Memorandum ABP-317810 - Request for Further Information under Section 131

To: Paul Caprani, ADP
From: Laura Finn, PI
Re: 317810 - Request for Further Information
Date: 12th January 2024

Re: Open Cycle Gas turbine power plant (350MW) and associated infrastructure
Located on land to the north of Tynagh Power Station, Derryfrench, Tynagh, Loughrea, Co. Galway.

Re: ABP-317810-23, Open cycle gas turbine power plant (350 MW) and associated infrastructure located on land to the North of Tynagh power station, Derryfrench, Tynagh, Loughrea, Co. Galway

Figure 2: Wind Rose for Athenry meteorological station (2018 – 2022)

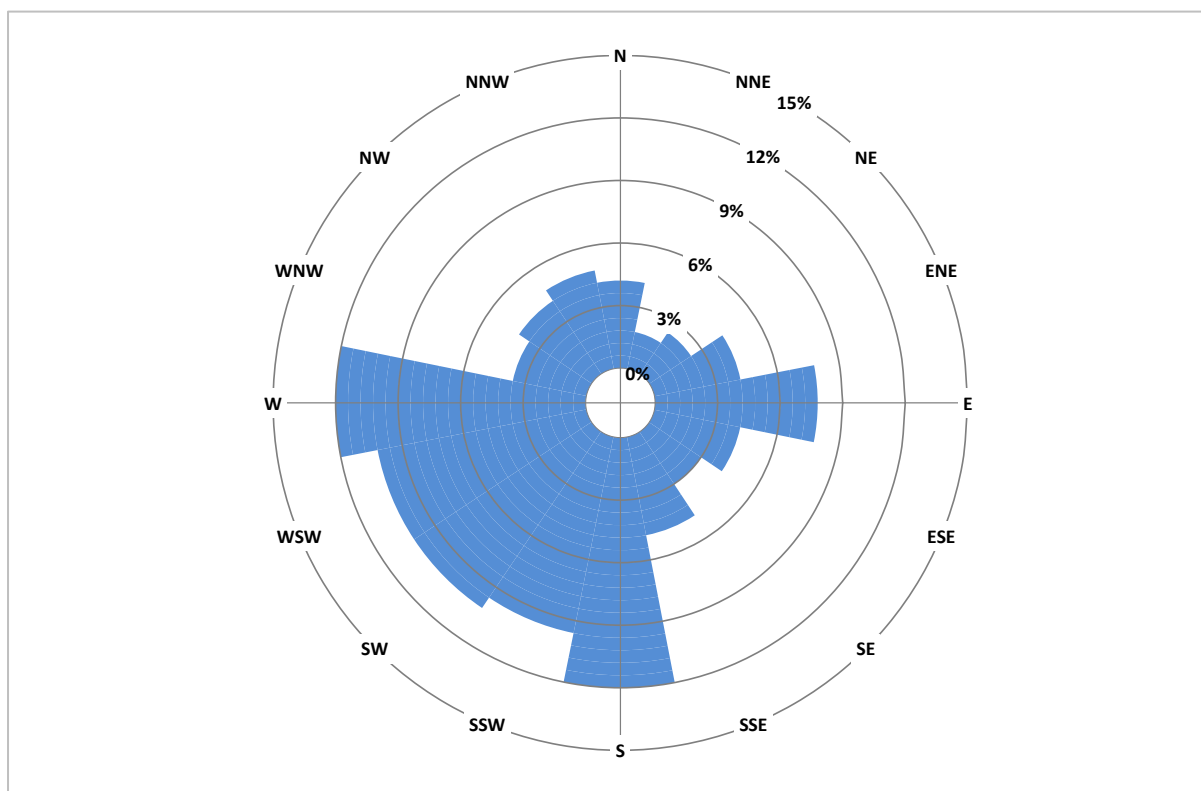
12. Section 5.2.2.2 – provide detail on meteorological data probabilities (i.e. 80/20 for D5/F2) or wind rose, which are relevant for flash fires for gas releases.

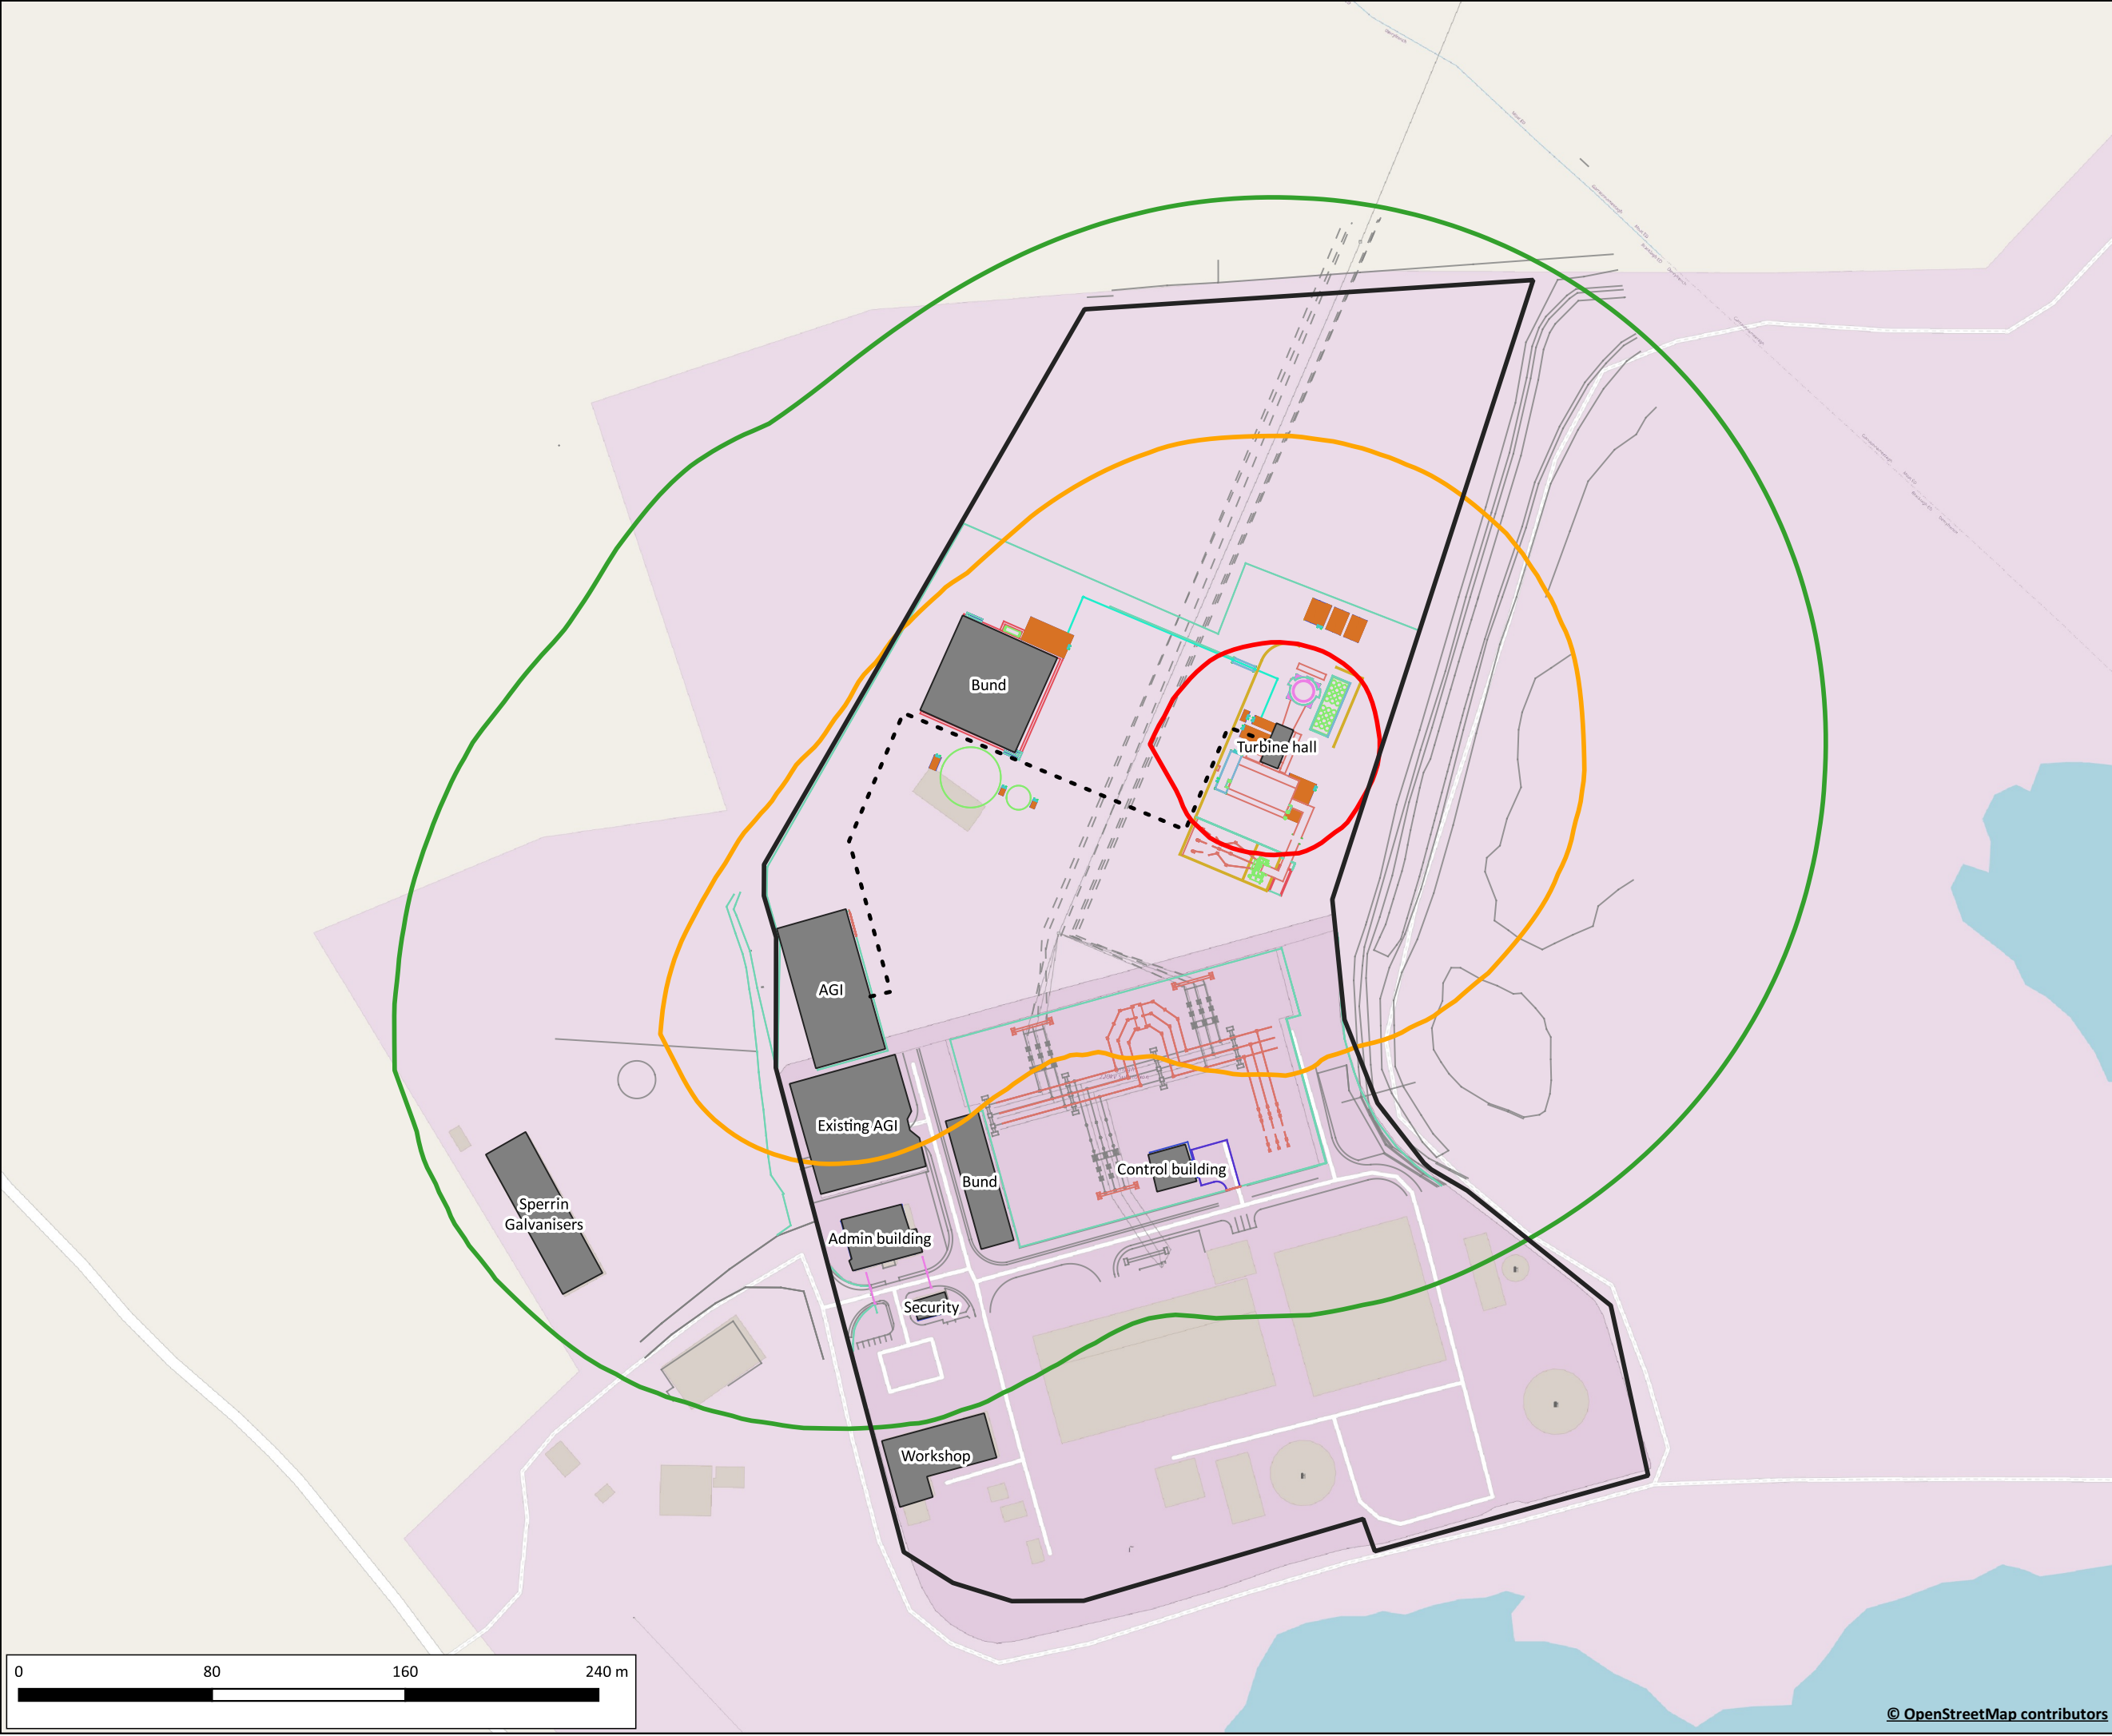
1. The report should include a drawing showing the site boundaries and the location/routes of all major hazards for all three COMAH installations – the current Tynagh Energy site, along with the Tynagh South and North sites. The drawing should show over ground and underground gas pipelines, AGIs, fuel storage bunds, CCGT and OCGT gas turbine enclosure locations, power station turbine hall, hydrogen operations etc. The report does not make clear the location of the Tynagh North OCGT turbine enclosures (only the AGI, fuel bund and underground gas pipelines are shown).
